Project name: Allen Robert

Project Address: 102 sonora dr, lillington, nc 27546

RESPONSE LETTER

SHEET NUMBER
E-601

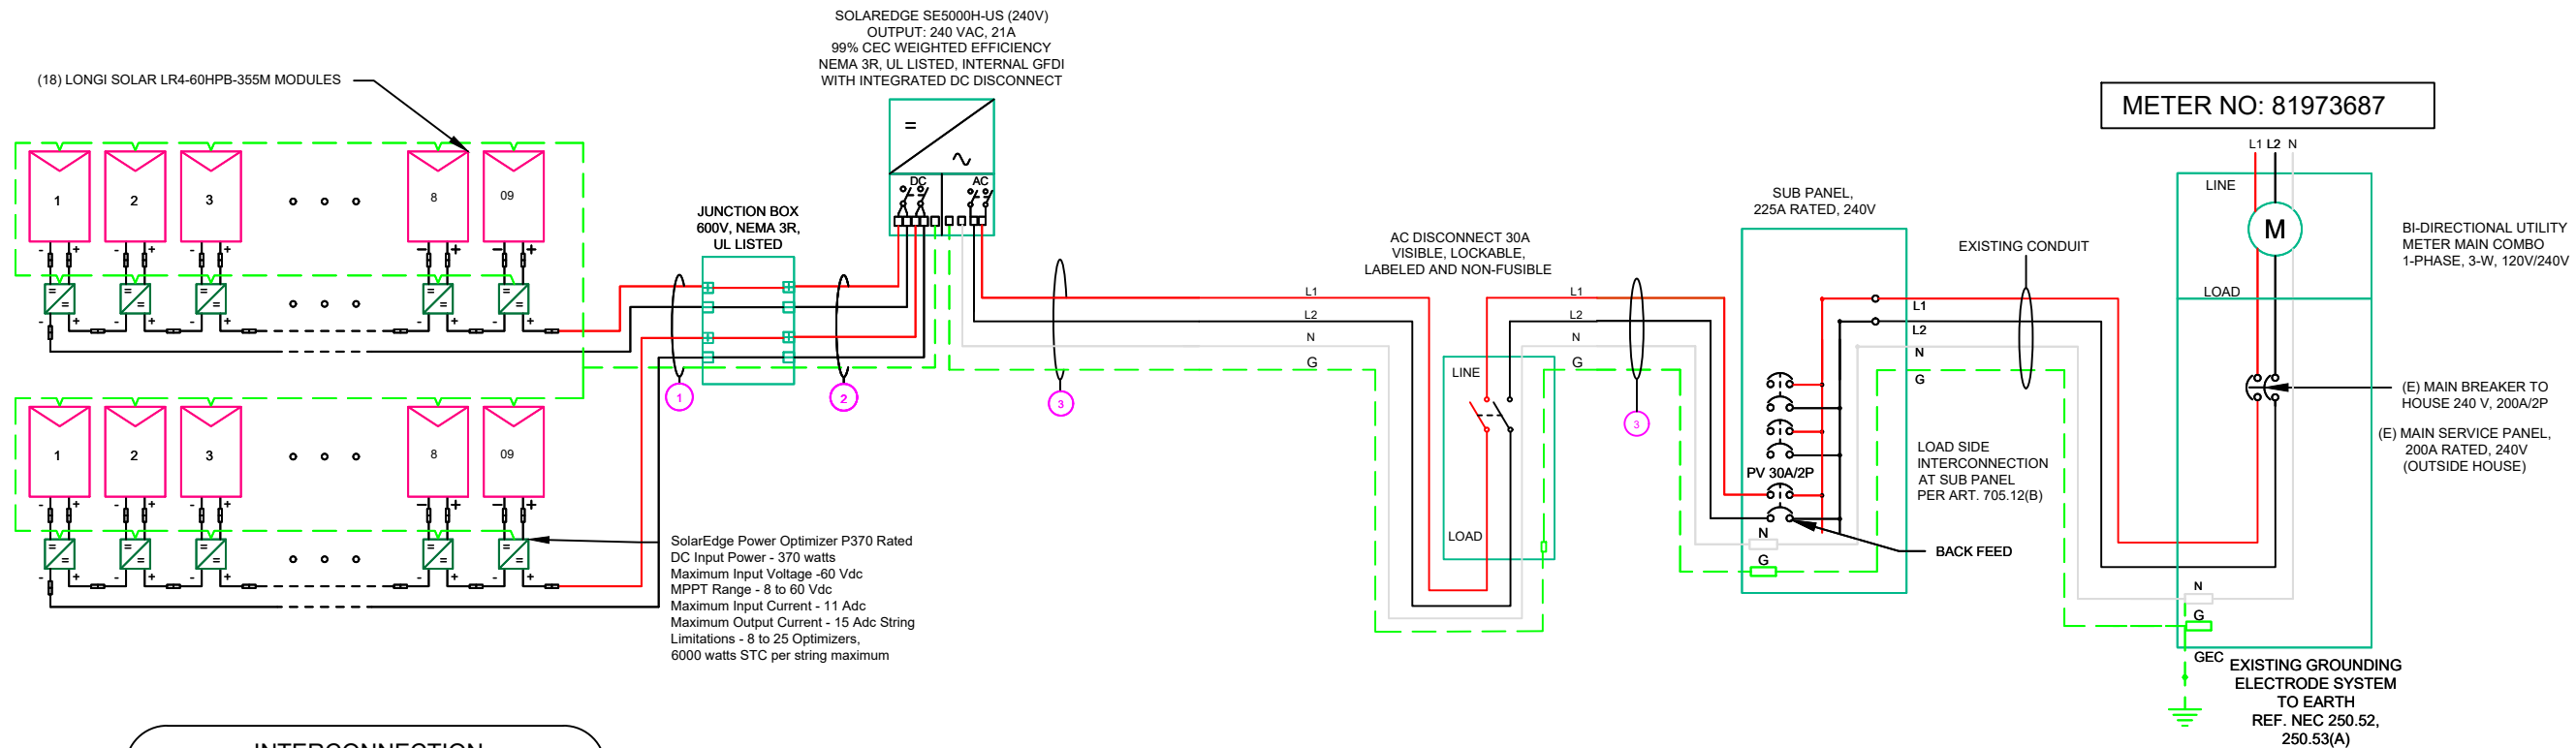
1. Updated one line as per revision note. Changed tag 4 to existing conduit.
